INFRASTRUCTURE PLANNING

**The M25 Junction 10/A3 Wisley Interchange Development
Consent (Amendment) Order 202[]**

2.—(1) The M25 Junction 10/A3 Wisley Interchange Development Consent Order 2022 is amended as follows.

Drawing Title: **SPEED LIMITS AND TRAFFIC REGULATIONS PLANS REGULATION 5(2)(o) SHEET 3 OF 9**

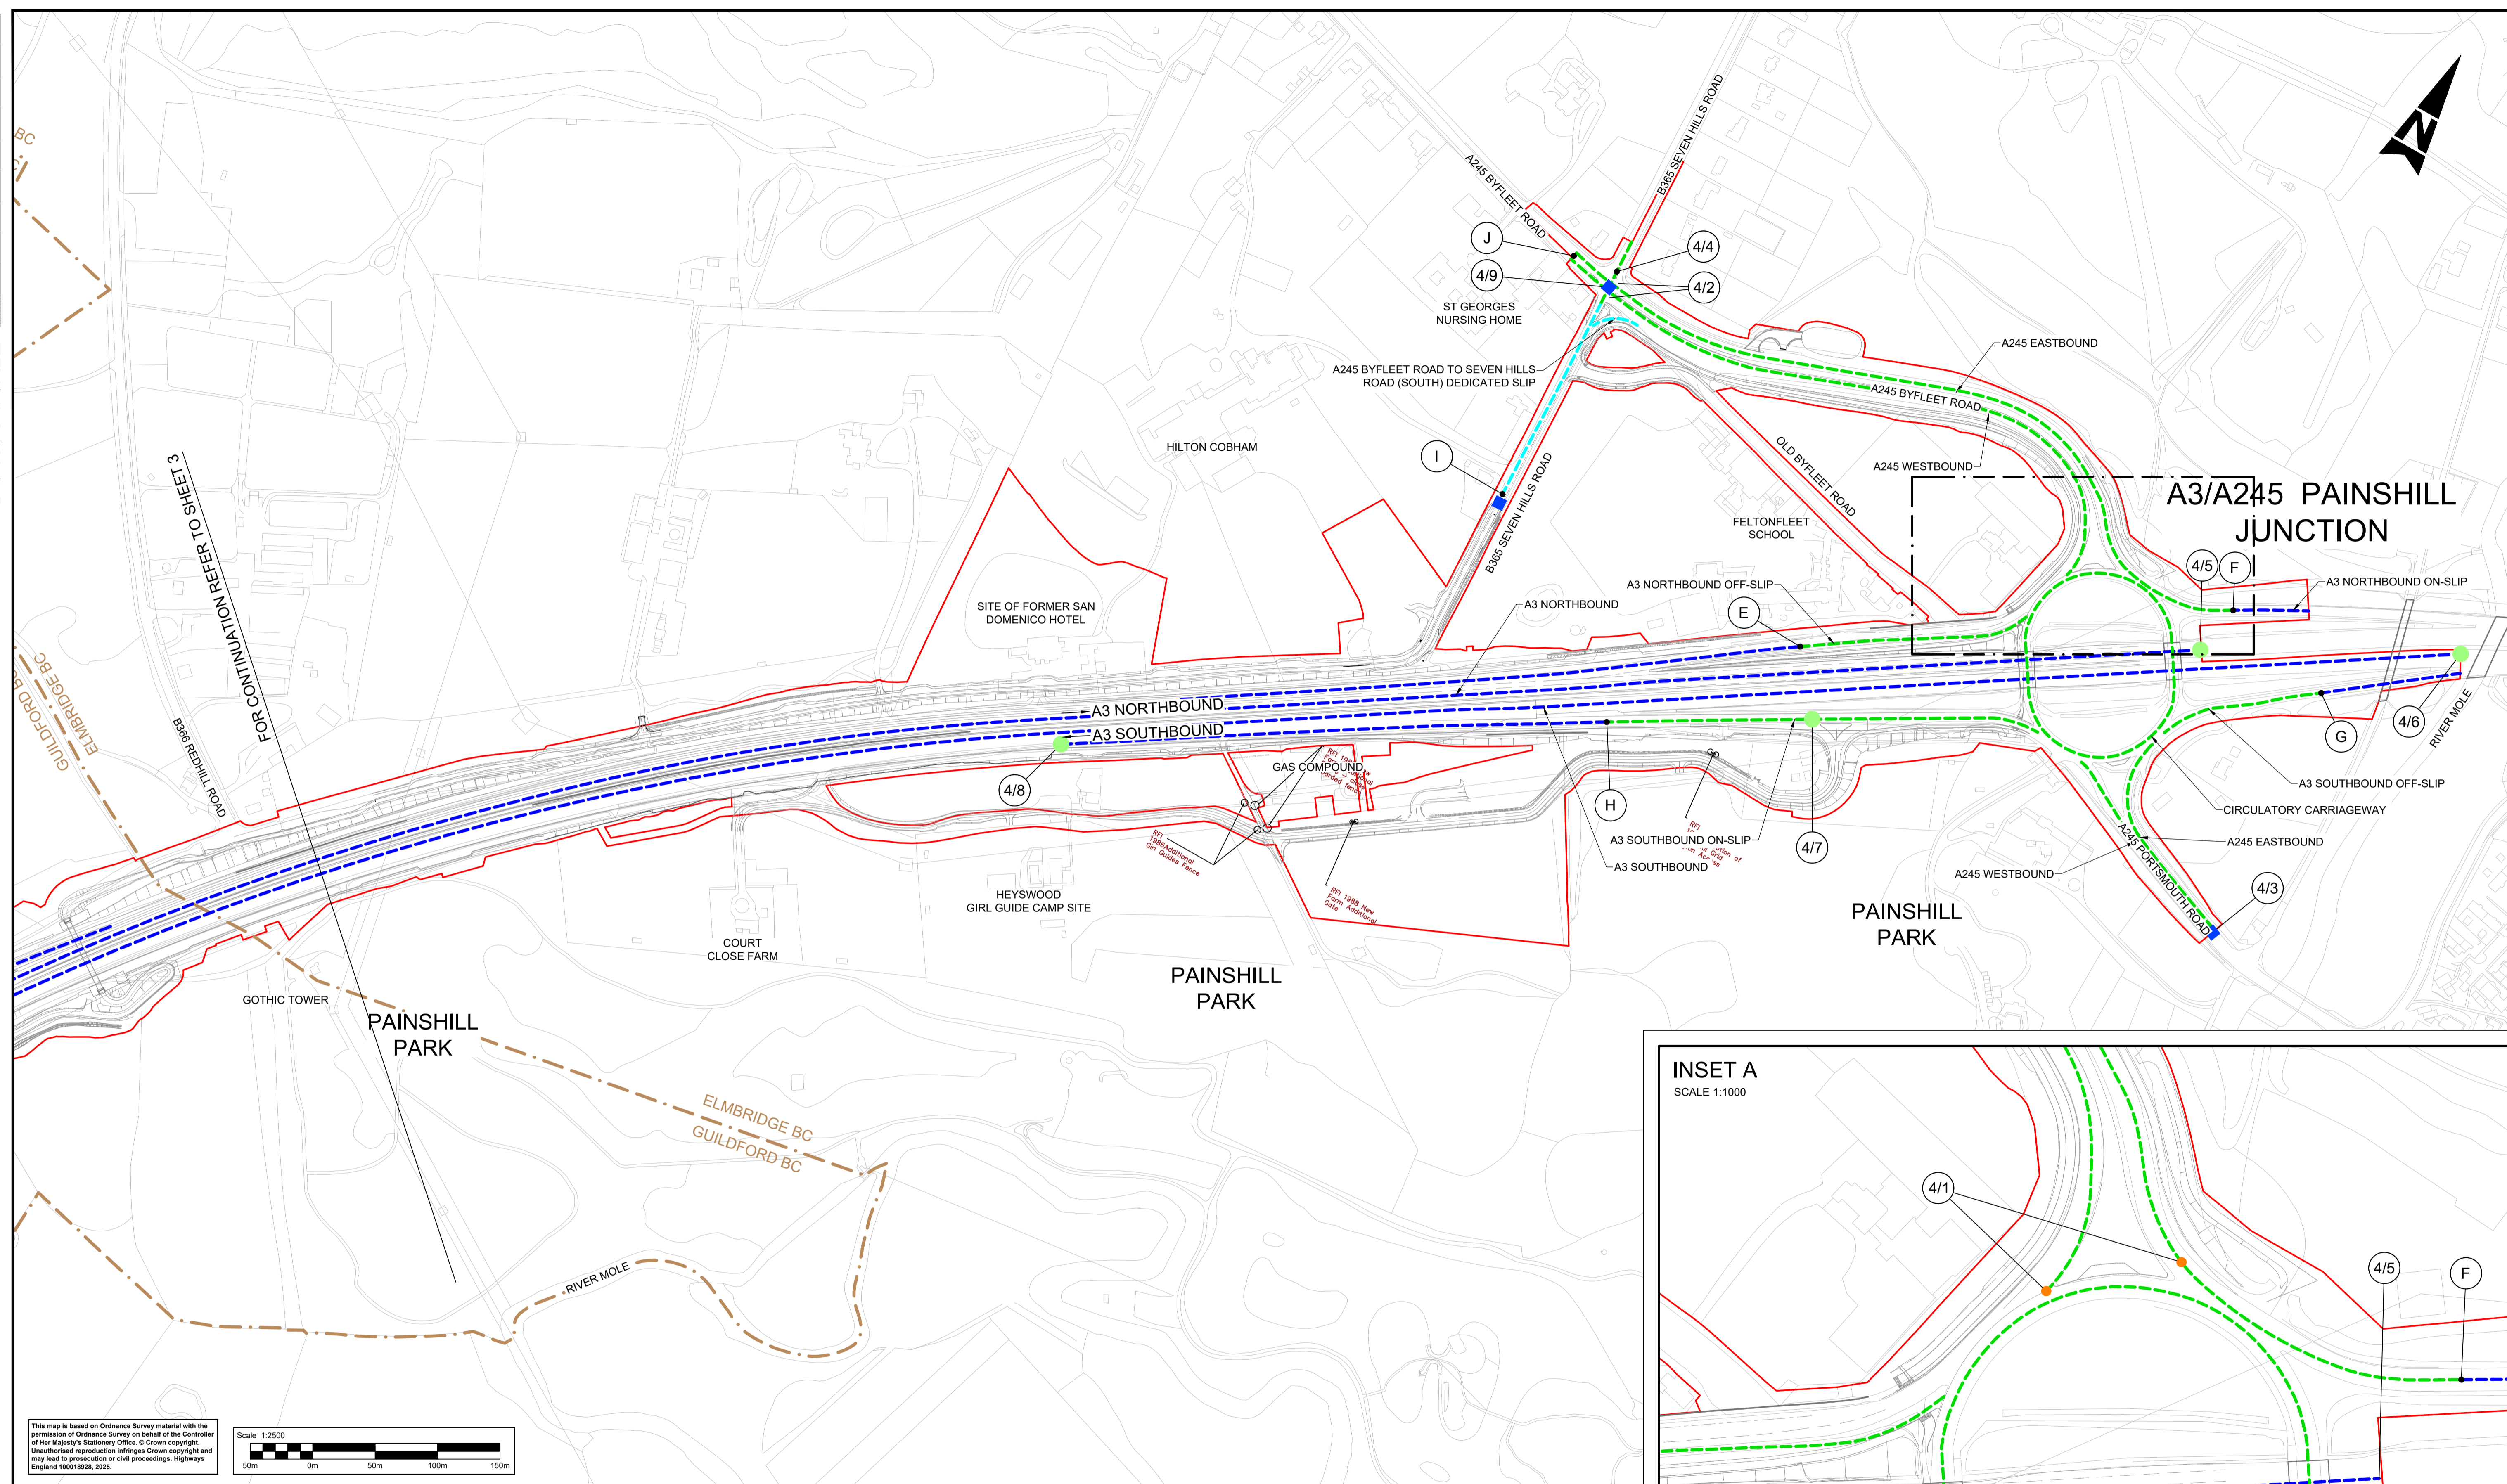
(2) In Schedule 3 (classification of roads, etc.) omit the following rows from the table at Part 5 (speed limits)—

<i>(1)</i> <i>Road name and number</i>	<i>(2)</i> <i>Extent</i>	<i>(3)</i> <i>Speed Limit</i>
M25 eastbound	Along the length of the improved M25 eastbound carriageway, for a total distance of 5,580 metres, as shown on Sheets 3, 5, 7 and 9 of the speed limits and traffic regulations plans.	National speed limit (70 miles per hour, as existing limit)
M25 eastbound on-slip at M25 junction 10	Along the length of the altered slip road, from its diverge from the M25 junction 10 circulatory carriageway to its merge with the M25 eastbound carriageway, for a total distance of 955 metres, as shown on Sheets 3 and 7 of the speed limits and traffic regulations plans.	National speed limit (70 miles per hour, as existing limit)
M25 westbound	Along the length of the improved M25 westbound carriageway, for a total distance of 6,050 metres, as shown on Sheets 3, 5, 7 and 9 of the speed limits and traffic regulations plans.	National speed limit (70 miles per hour, as existing limit)

M25 westbound on-slip at M25 junction 10	Along the length of the improved slip road, from its diverge from the M25 junction 10 circulatory carriageway to its merge with the M25 westbound carriageway, for a total distance of 1,225 metres, as shown on Sheets 3 and 5 of the speed limits and traffic regulations plans.	National speed limit (70 miles per hour, as existing limit)
A3 northbound to A245 westbound dedicated slip lane at the A3 Painshill junction	Along the length of the new slip road, from its diverge from the A3 northbound off-slip to its merge with the A245 westbound carriageway, for a total distance of 180 metres, as shown on Sheet 4 of the speed limits and traffic regulations plans.	40 miles per hour

(4) In Schedule 11 (documents to be certified) in relation to the entry in the table for “Speed Limits and Traffic Regulation Plans”—

- (a) in the second column of that table (Document Reference) replace the document reference with TR010030/APP/2.8; and

(b) in the third column of that table (Revision) replace the revision number with “4”.

Project Title	M25 JUNCTION 10 / A3 WISLEY INTERCHANGE IMPROVEMENT
Drawing Title	SPEED LIMITS AND TRAFFIC REGULATIONS PLANS REGULATION 5(2)(o) SHEET 4 OF 9
Drawing Number	HE551522
Project	BBA - LDC - WHL_ML_A3 - DR - ZL - 020704
Location	A1
Scale	1:2500
Project Ref. No.	5195939
Sheet	4 of 9
Rev	P02

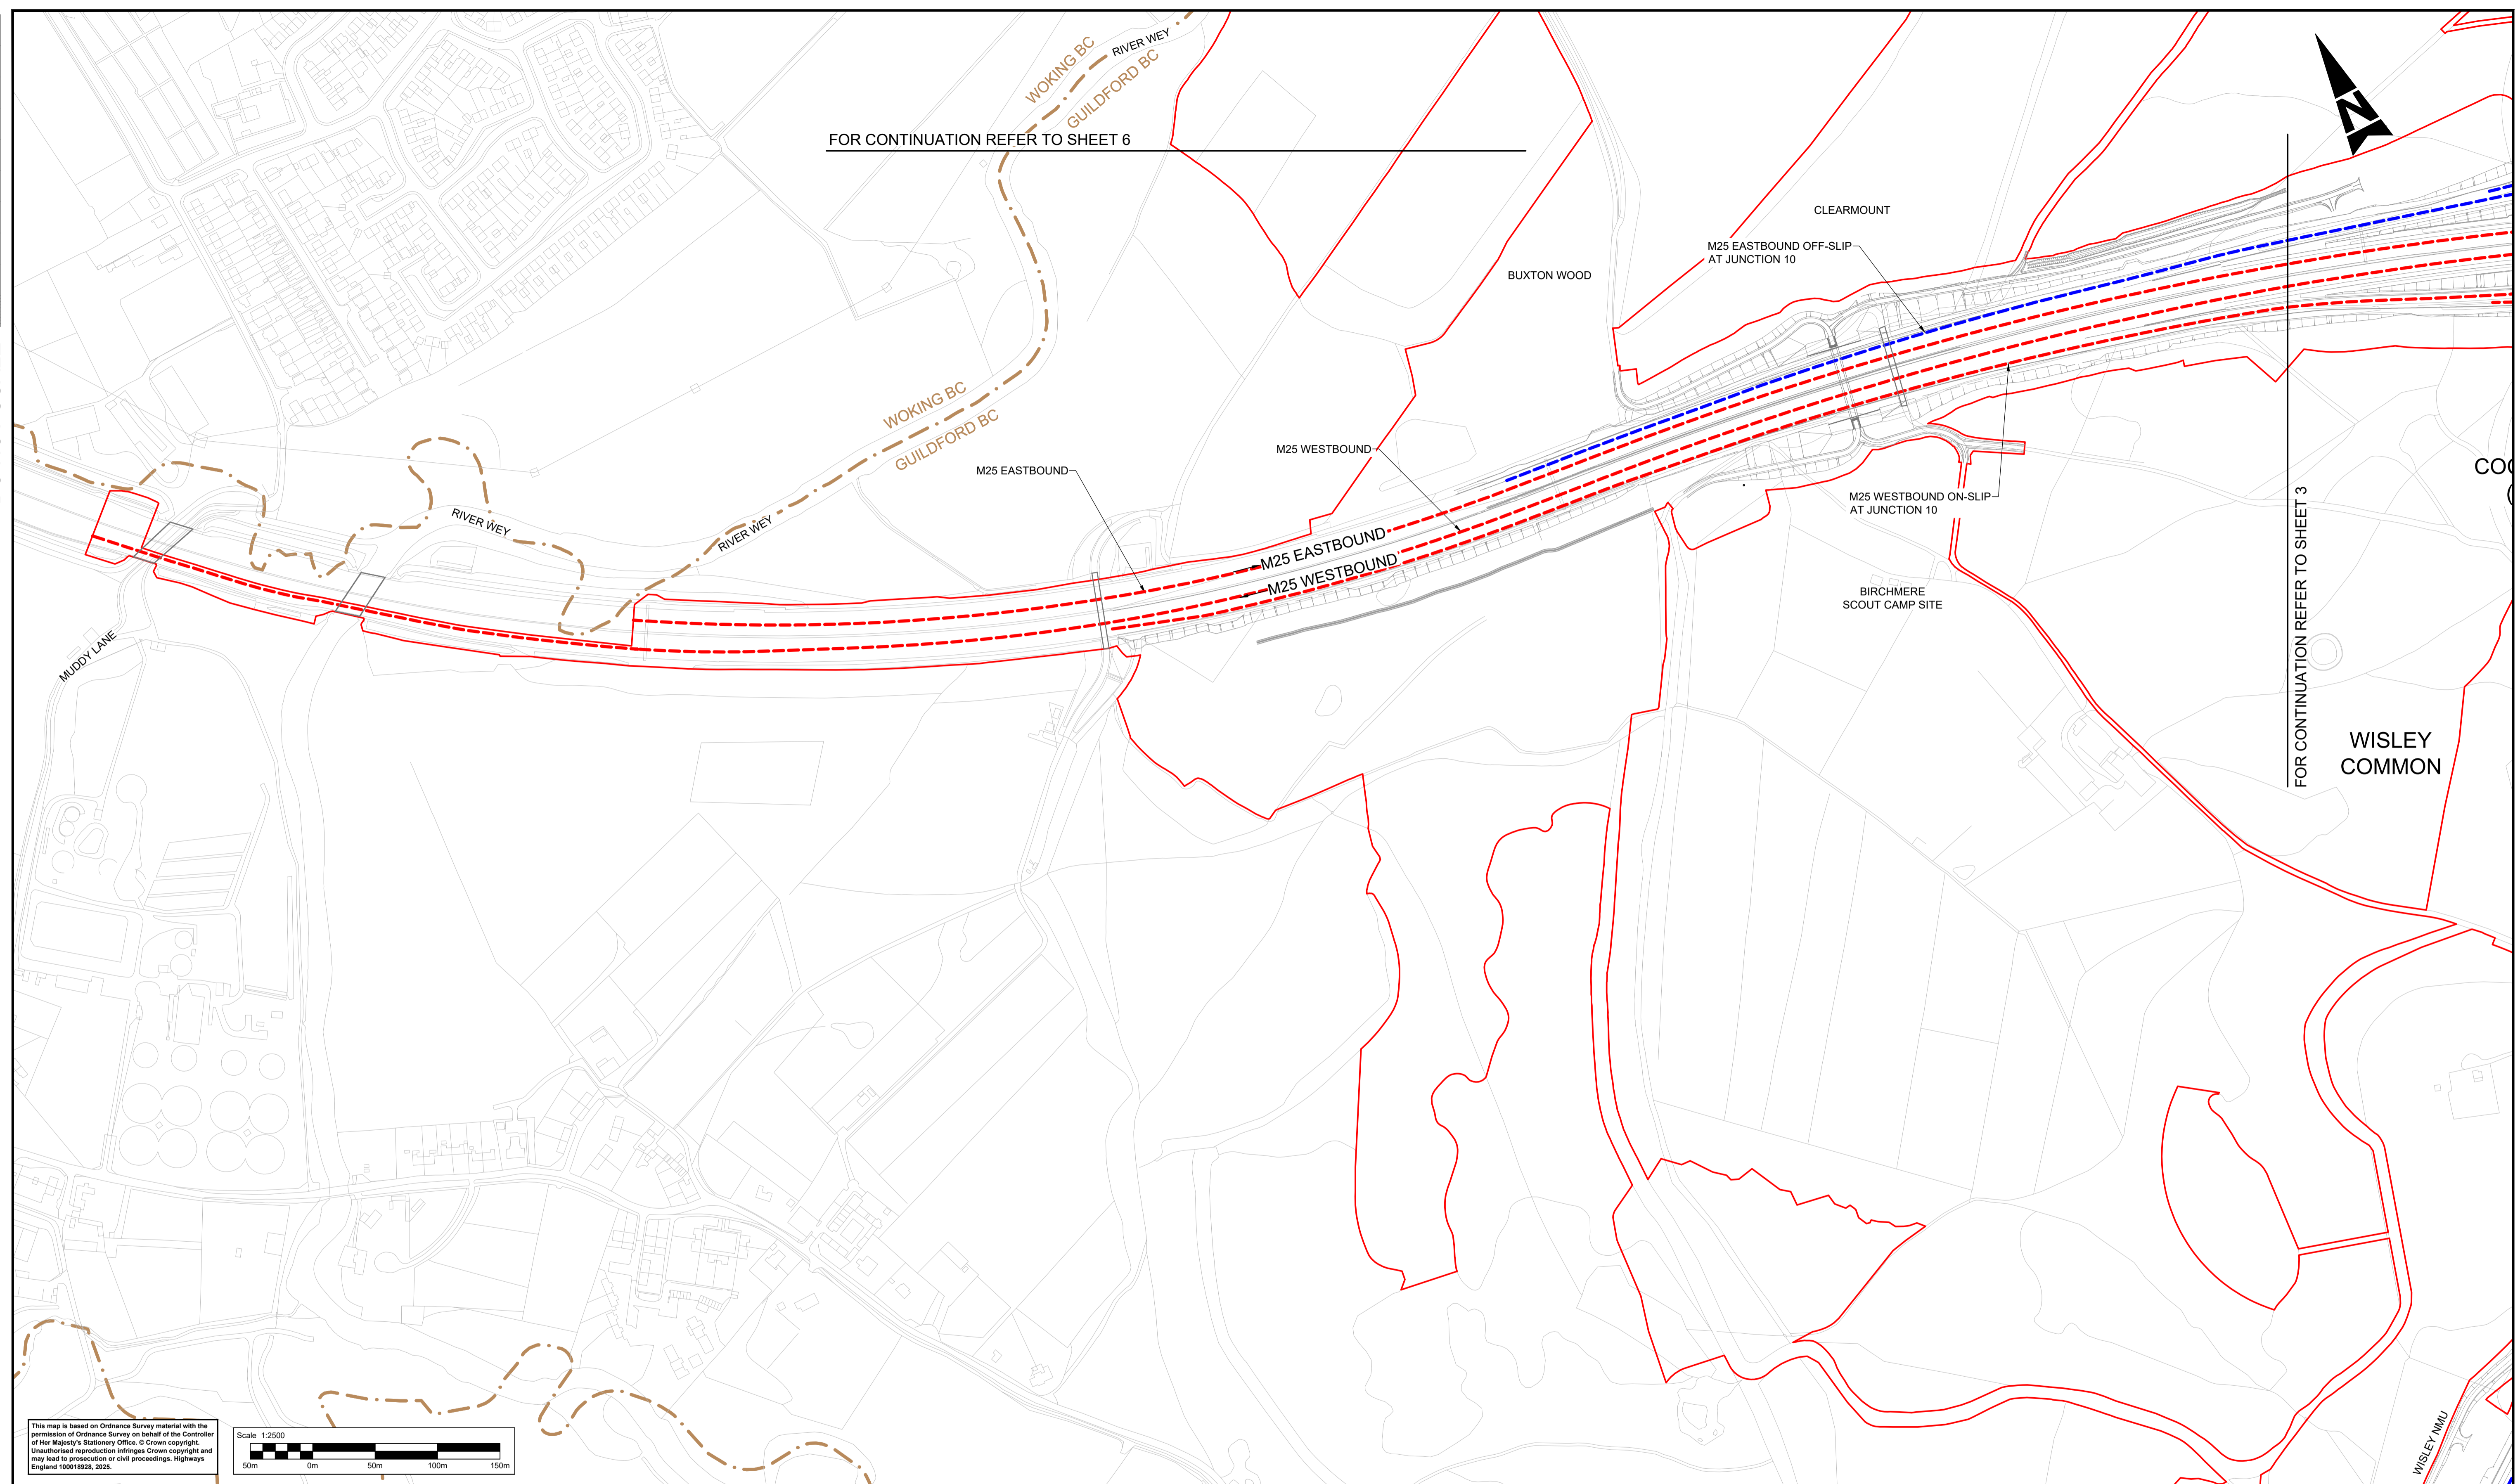
- (a) in the row relating to the “A3 northbound to M25 westbound dedicated free-flow slip lane at M25 junction 10”, in column (2) replace “205” with “39.12”; and
- (b) in the row relating to the “A3 southbound to M25 eastbound dedicated free-flow slip lane at M25 junction 10”, in column (2) replace “210” with “45.25”.
